CITY OF ALBUQUERQUE

July 23, 2024

Re: Flite Banking Centers LLC
3500 Coors Blvd SW
Traffic Circulation Layout
Engineer's/Architect's Stamp No Date (P10D004A)

SITE LAYOUT PLAN

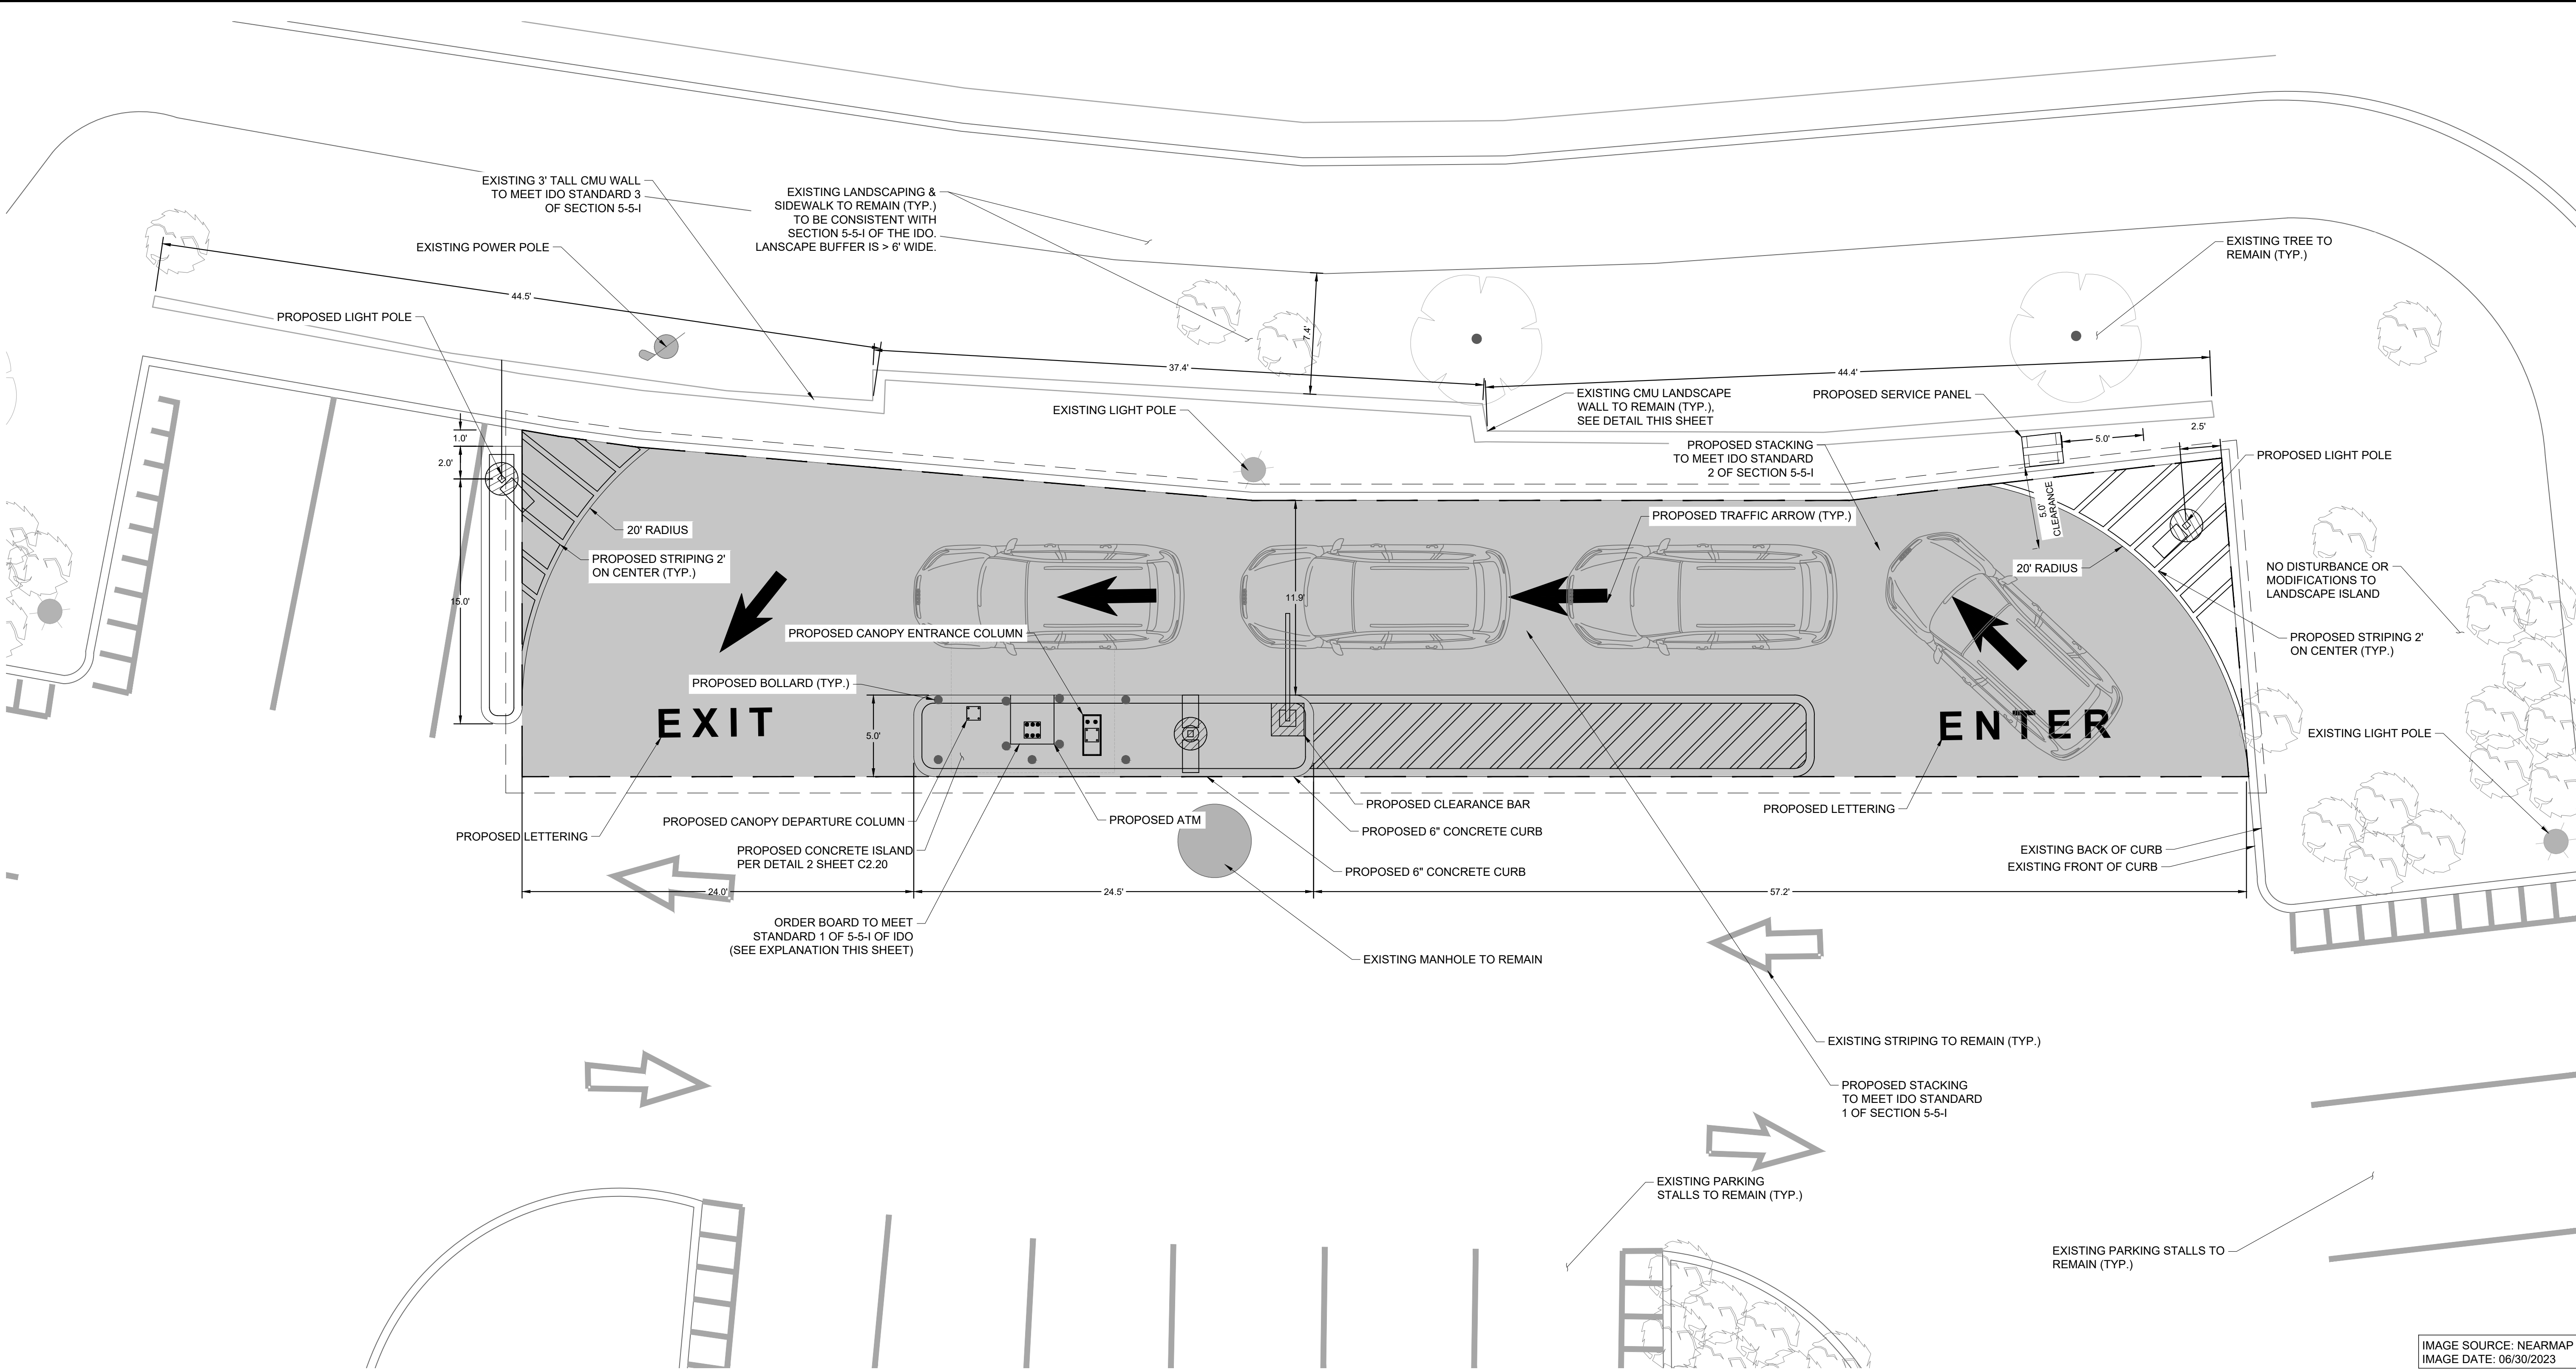
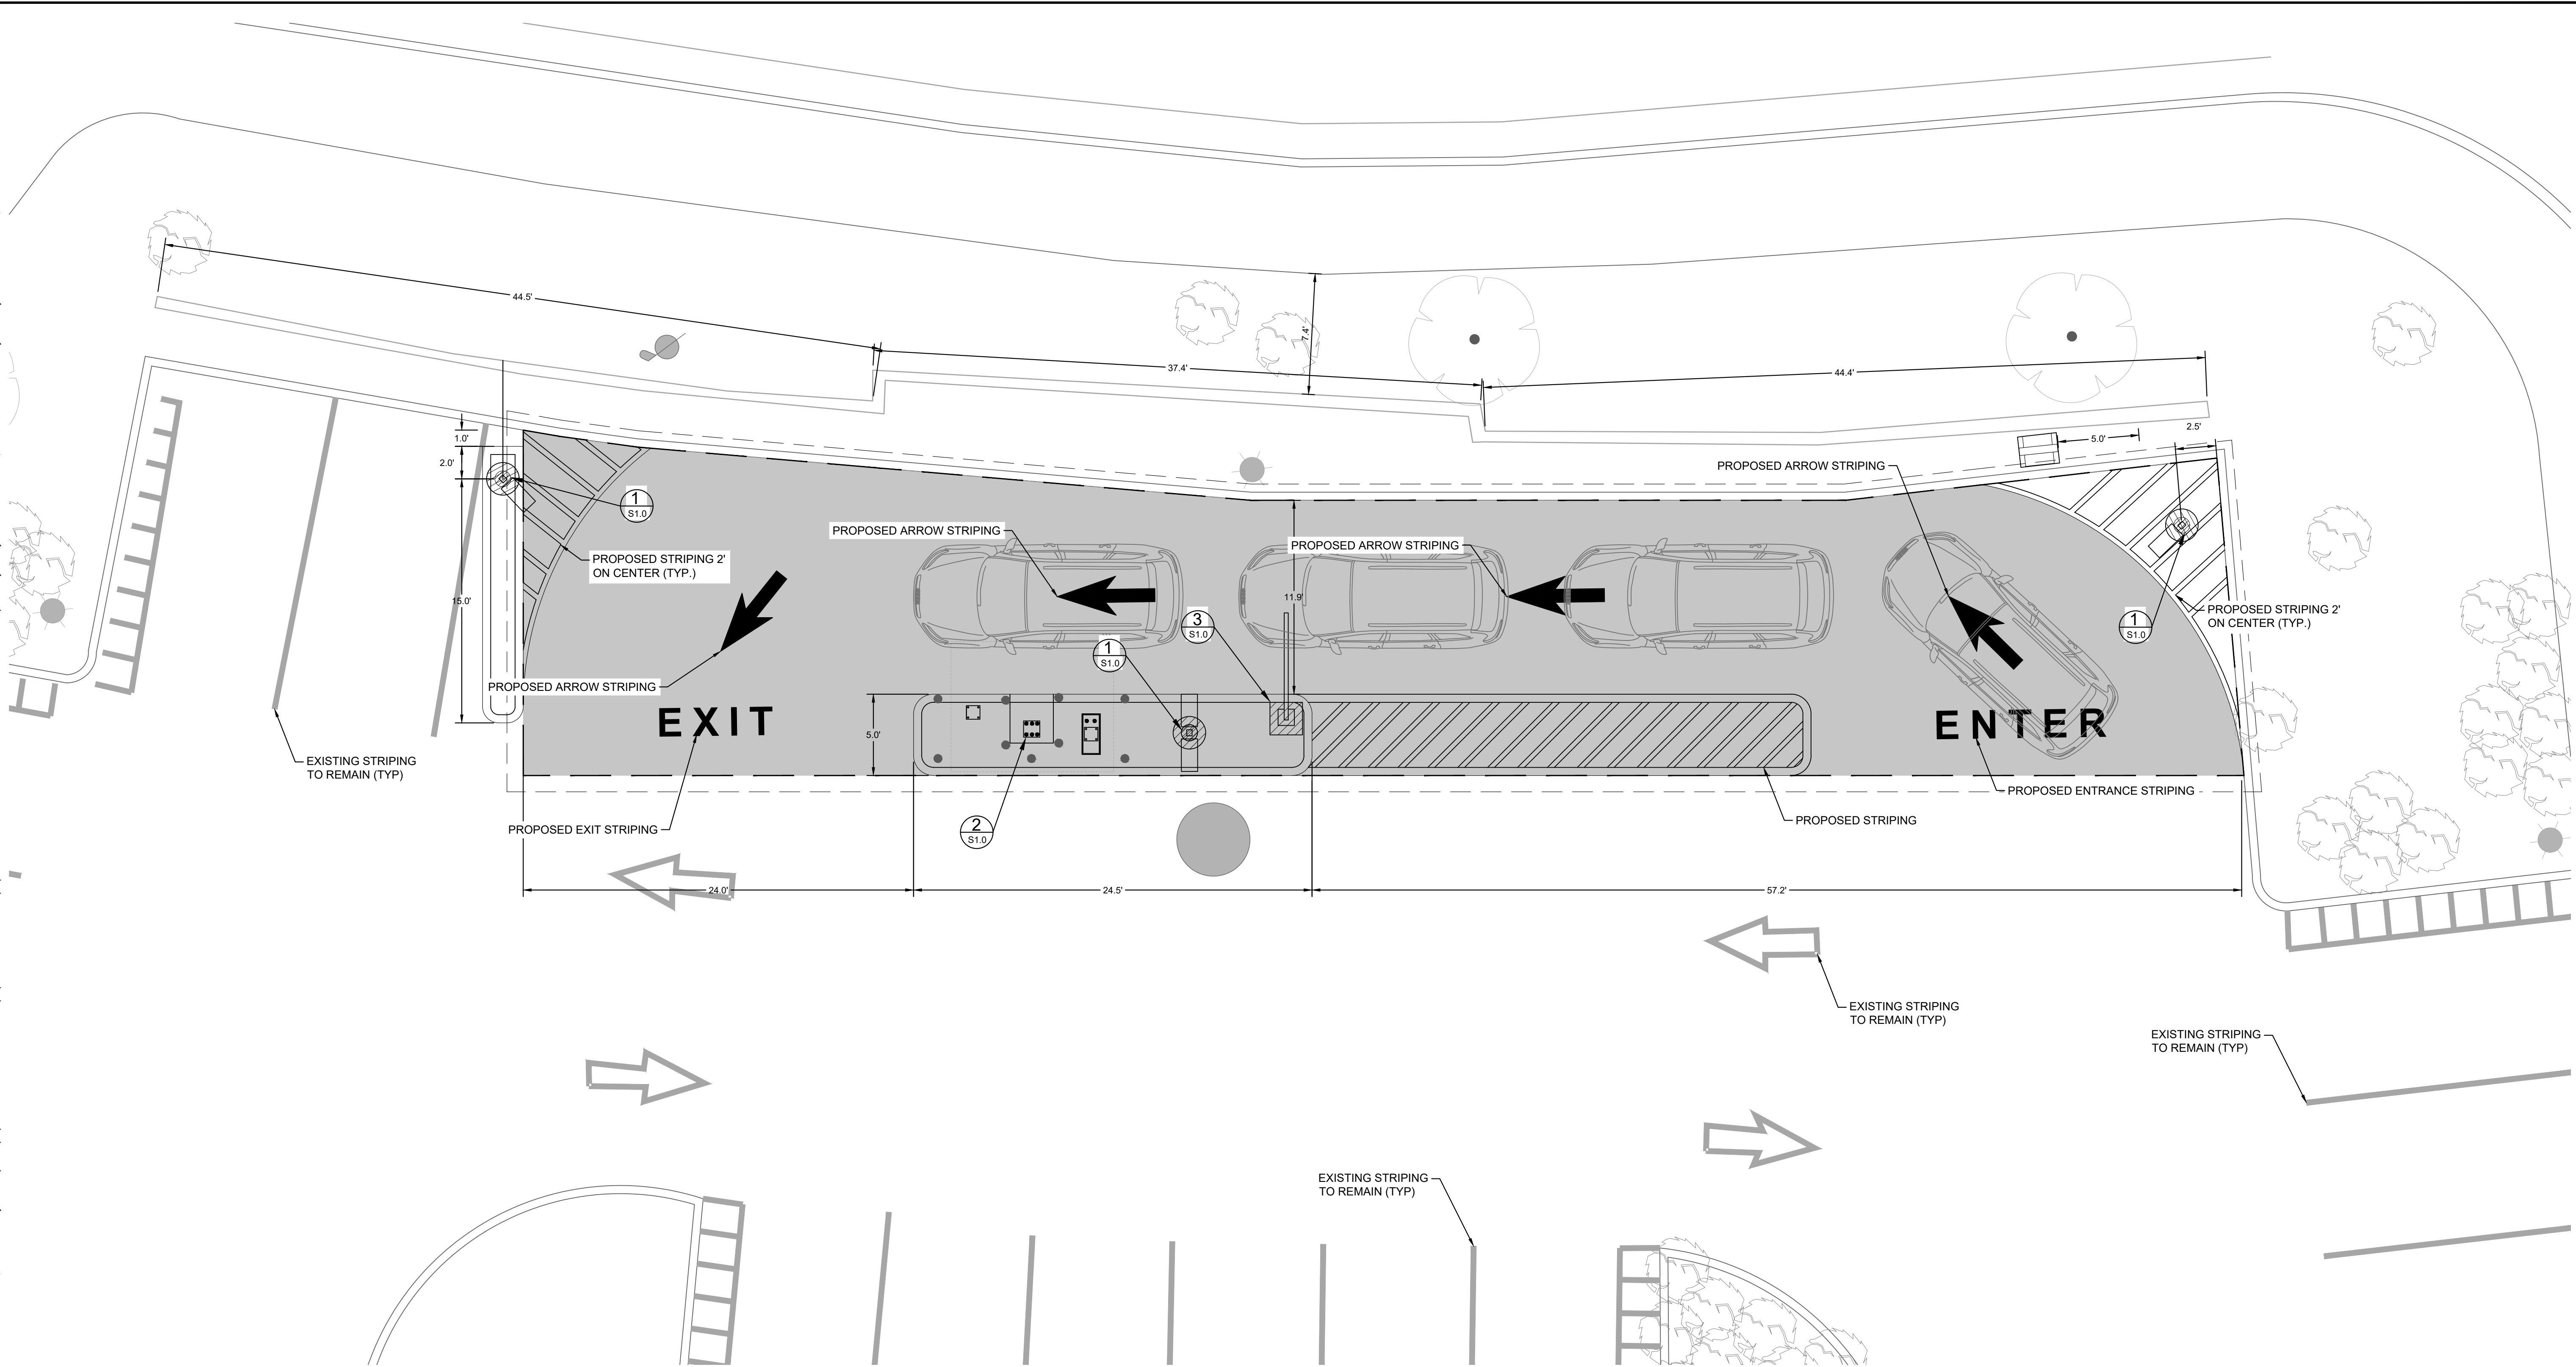
1. The traffic circulation layout must be stamped, signed, and dated by an engineer or architect licensed in the state of New Mexico.
2. All one-way drives shall have "One Way" and "Do Not Enter" signage and pavement markings. Please show detail and location of posted signs and striping.
3. The minimum drive through lane width is 12 feet with a 25 foot minimum radius (inside edge) for all turns.

4. Minimum required stacking spaces (of 20 ft each) is 4 spaces measured from end of queuing lane to Teller window/ATM. Add another space and label the dimension of each space in the drive through lane.
5. Add a note stating "All broken or cracked sidewalk must be replaced with sidewalk and curb & gutter." A build note must be provided referring to the appropriate City Standard drawing.
